City of Albuquerque SWPPP Inspection Checklist

| Project Name: | Kairas Power | Project Operator: | Kairas Power |
| Project Location: | 5700 Hawking | Contact Name: | Rhonda Reynolds ETP |
| Date of Inspection: | 2-2-2026 | Contact Email: | Reynolds@KairasPower.com |

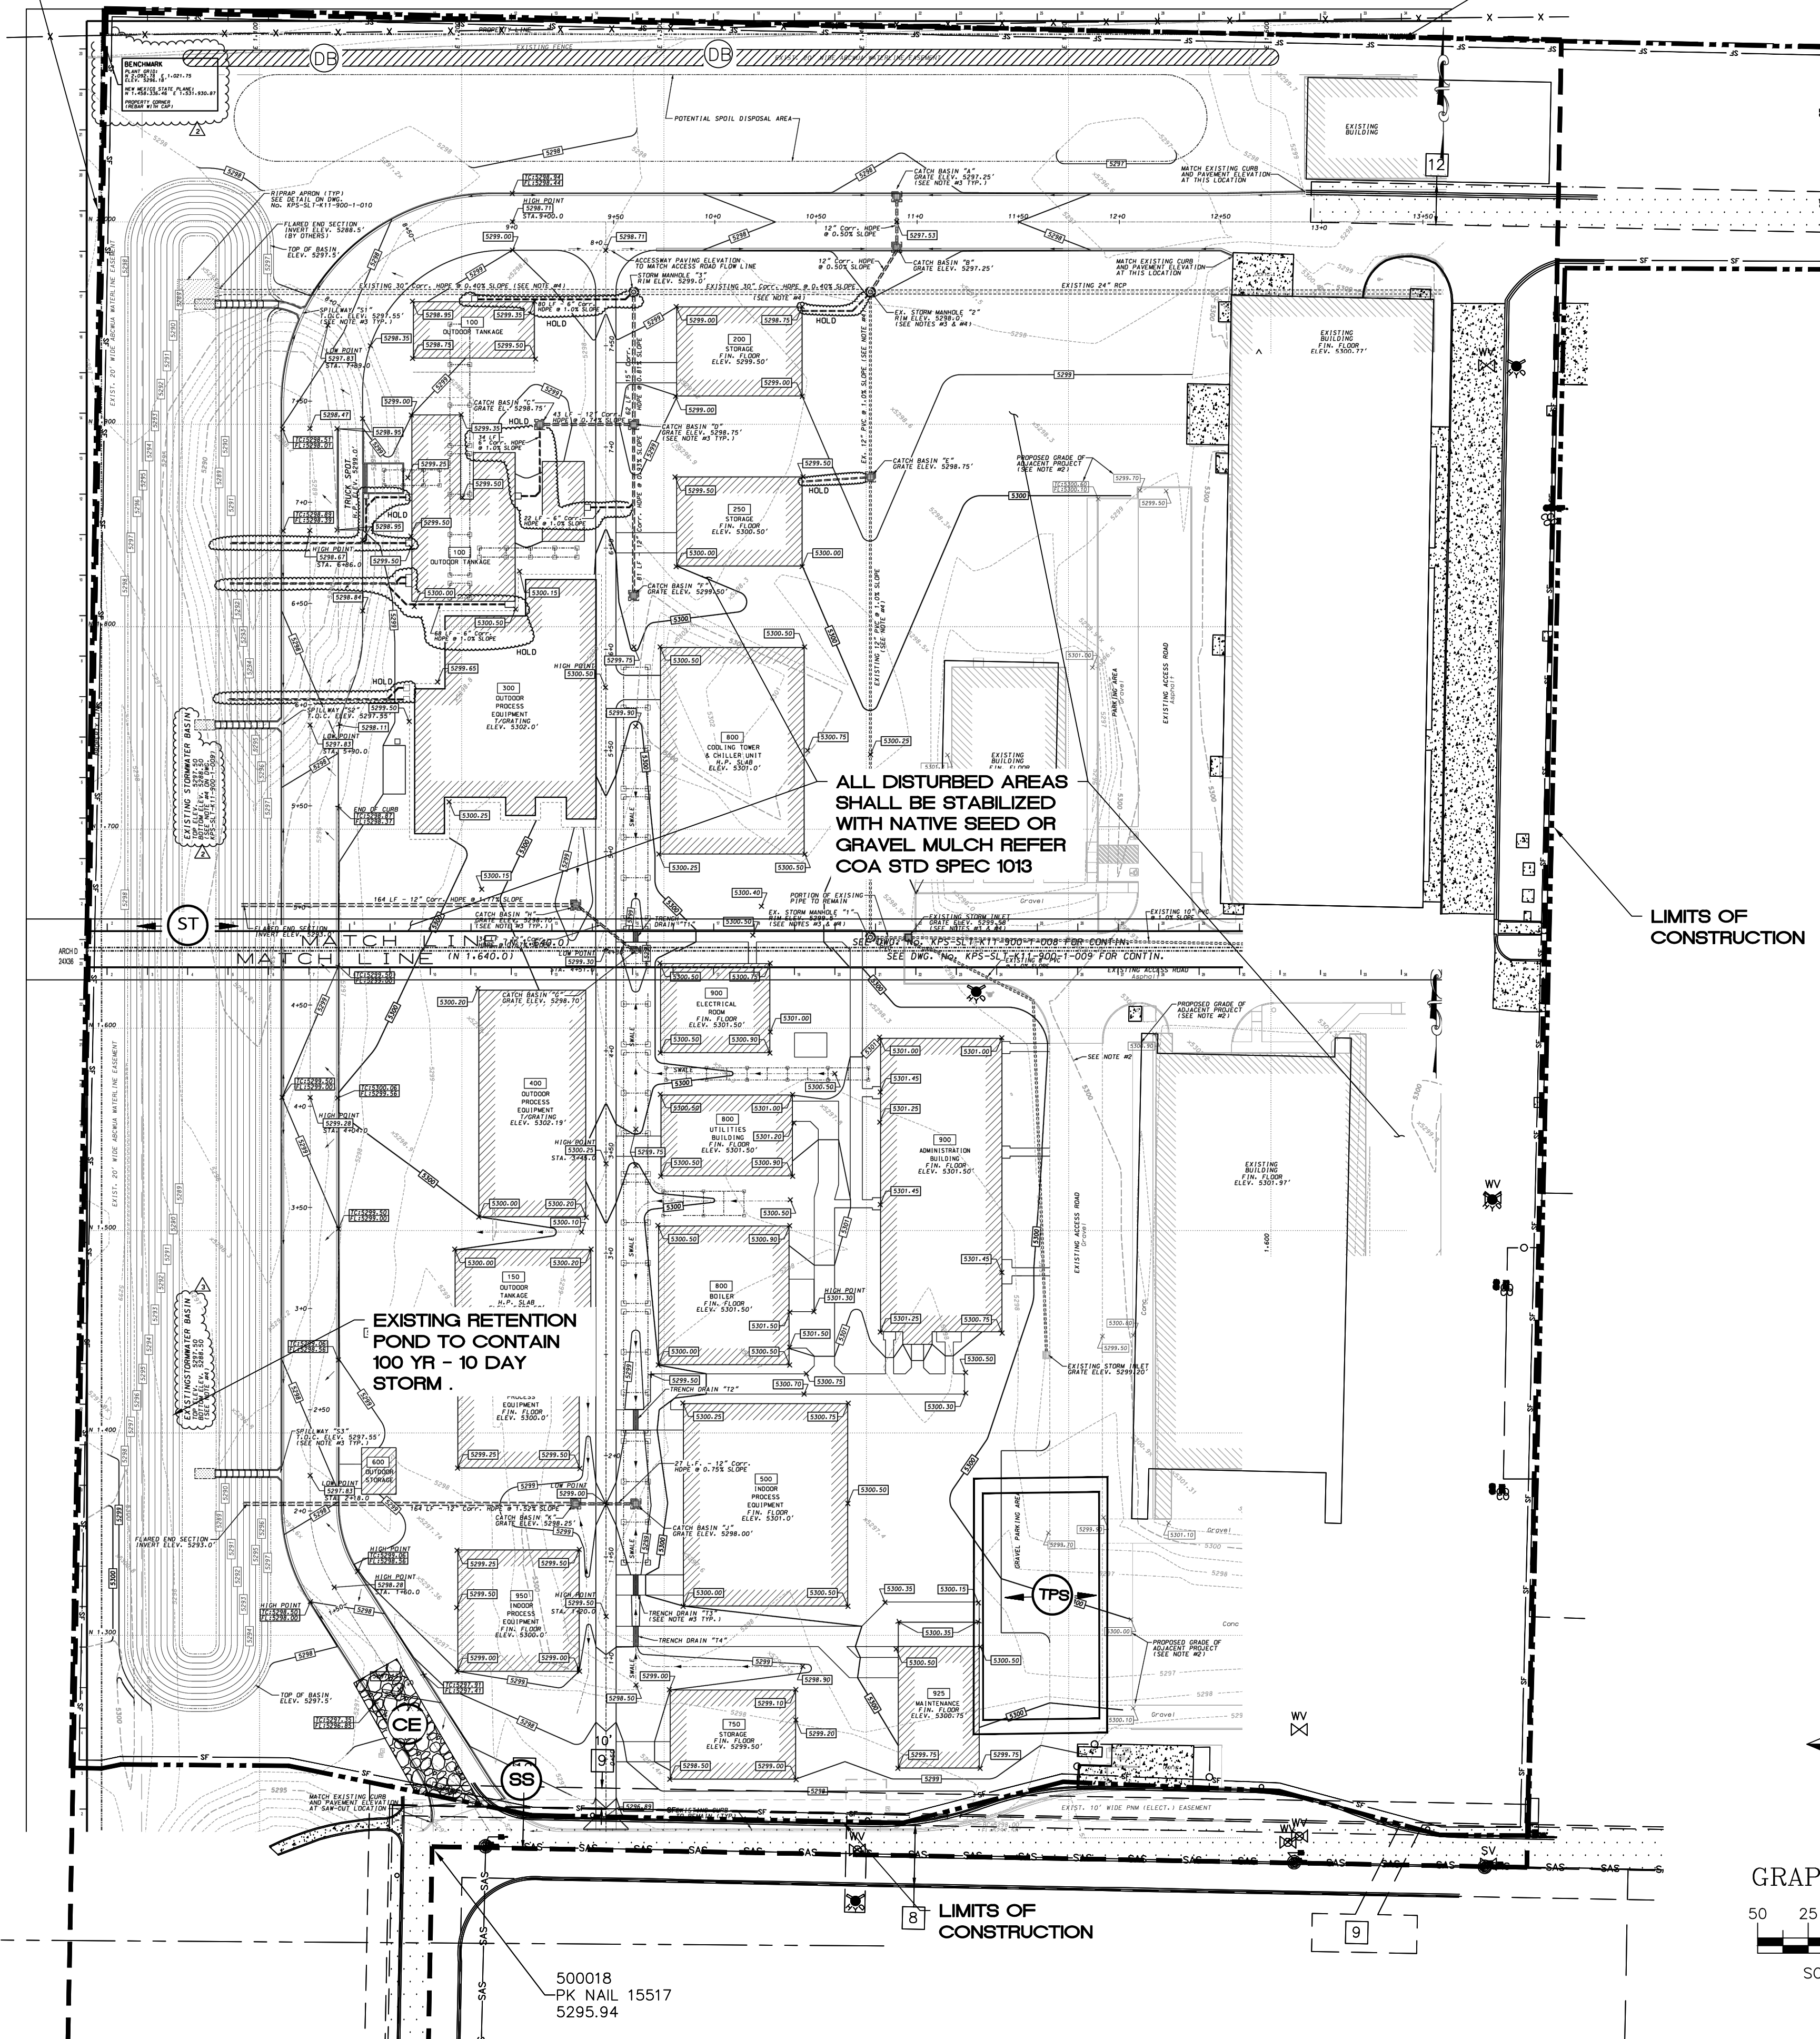
| SWPPP Requirements | CGP (SWPPP – EPA Template) | YES | NO | COMMENTS |
|--|-----------------------------------|-------------------------------------|-------------------------------------|---|
| Are the Stormwater Team members identified? E-mail? Phone#? | 6 7.2.2 (Sec 1.2, 6) | <input type="checkbox"/> | <input type="checkbox"/> | Need a List |
| Has the site map been updated? | 7.2.4, 7.4 (App A) | <input type="checkbox"/> | <input checked="" type="checkbox"/> | May 2025 missing |
